**From:** Miriam Hill  
**Sent:** 18 September 2017 13:24  
**To:** Kerrie Charles  
**Subject:** 6/2017/1476/HOUSE - 31 Selwyn Crescent, Hatfield, AL10 9NL

Proposal: Erection of first floor front, side and rear extensions

Block Scale Plan 1:150

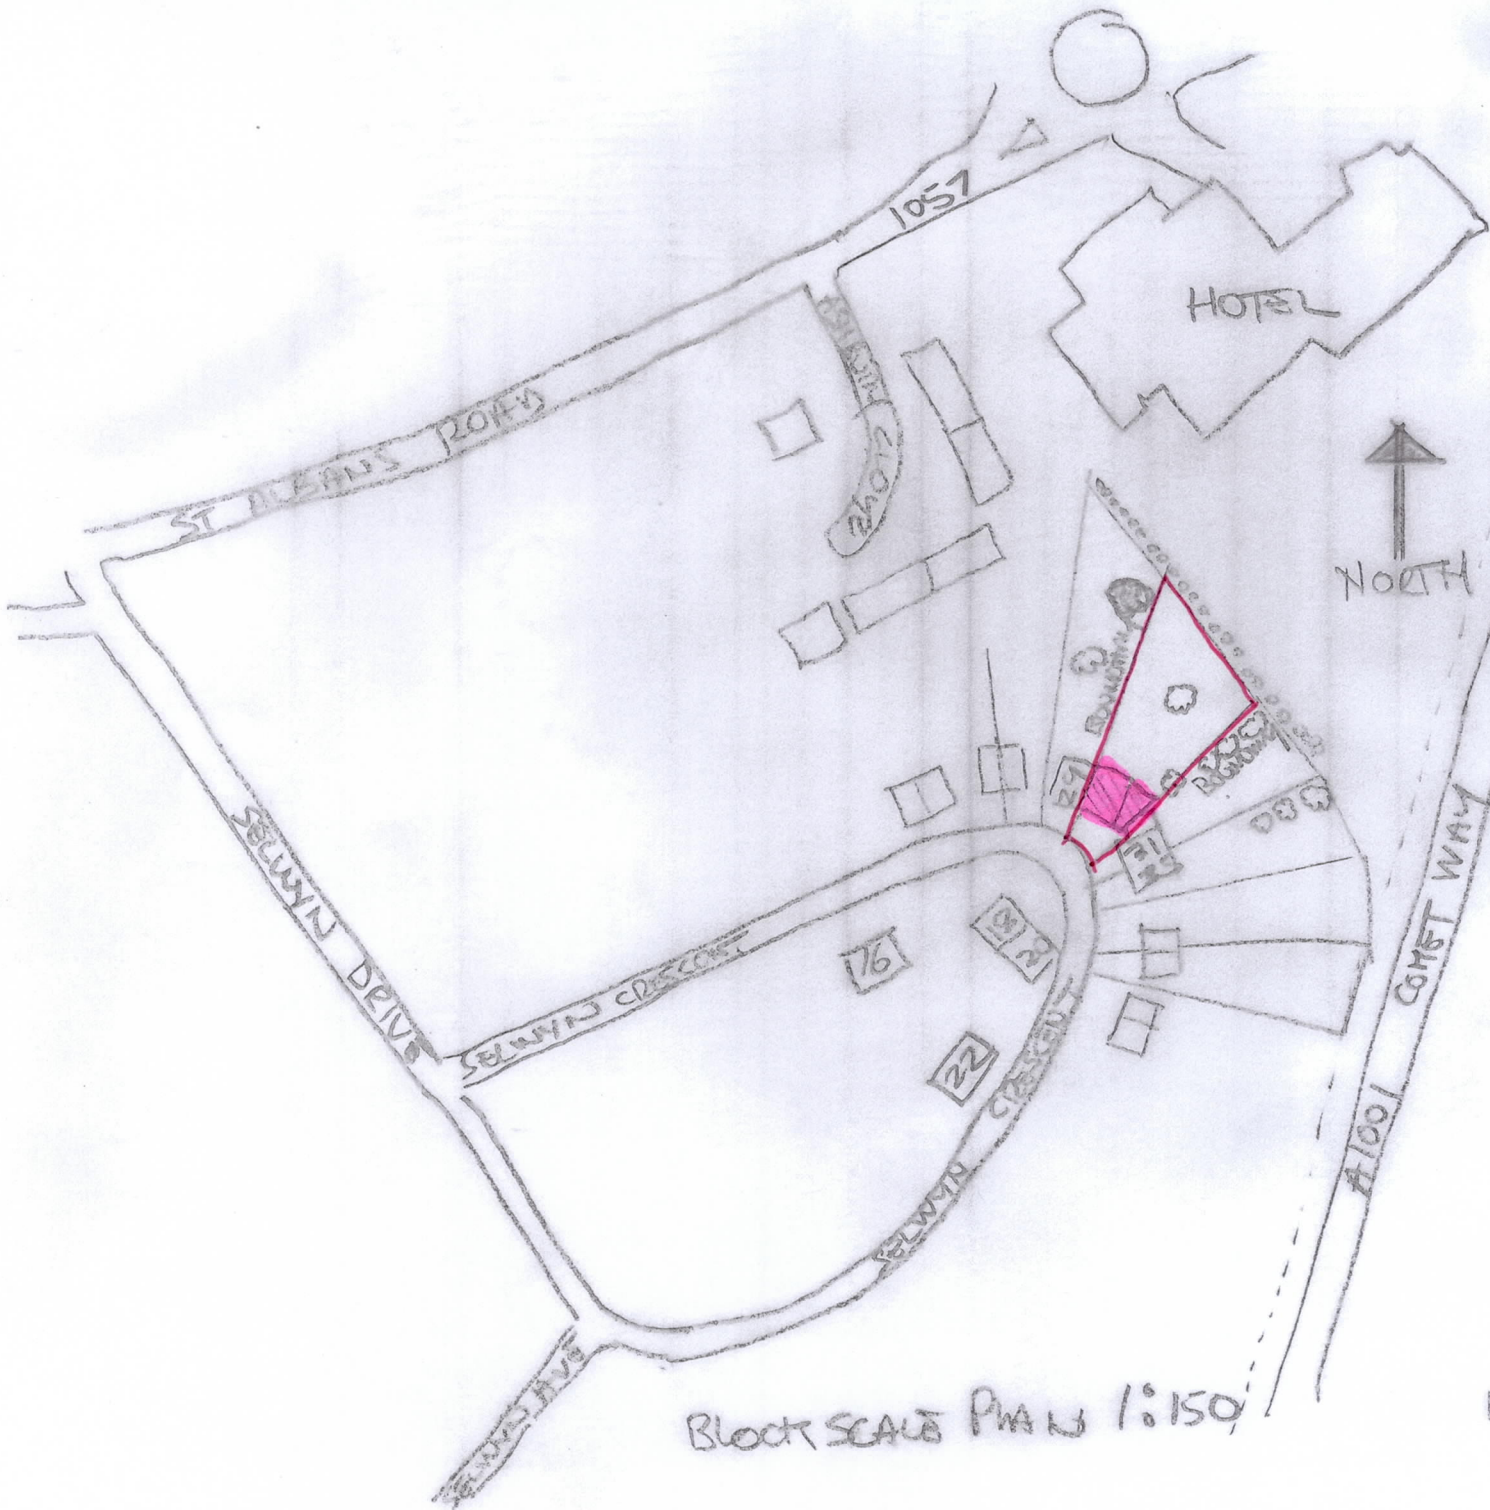
Comments: I have some concerns with the application and the existing trees both on and adjacent to site. Although the trees do not have a high amenity value, one or more of the trees do not stand within the application site. There is no indication that the application has considered these trees through an Arboricultural Implication Report. It is also possible that a neighbouring tree will immediately physically encroach onto the proposed extension, this conflict does not appear to be considered.

Should the application be approved a condition should be placed on the approval for the applicant to submit a Tree Protection Statement for the tree(s) either on, adjacent or on the roadside. It should cover how the applicant will ensure the tree parts, both above or below ground, will not be directly or indirectly damaged. The scale of the document should reflect the importance of the trees in the landscape and the size of the building works. The statement should reflect BS5837:2012 (Trees in relation to design, demolition and construction - Recommendations). For example, to avoid root damage by soil compaction, all site vehicles shall not park or drive on the verges. This Statement shall be submitted to the Council for approval before any works, including demolition, start on site.
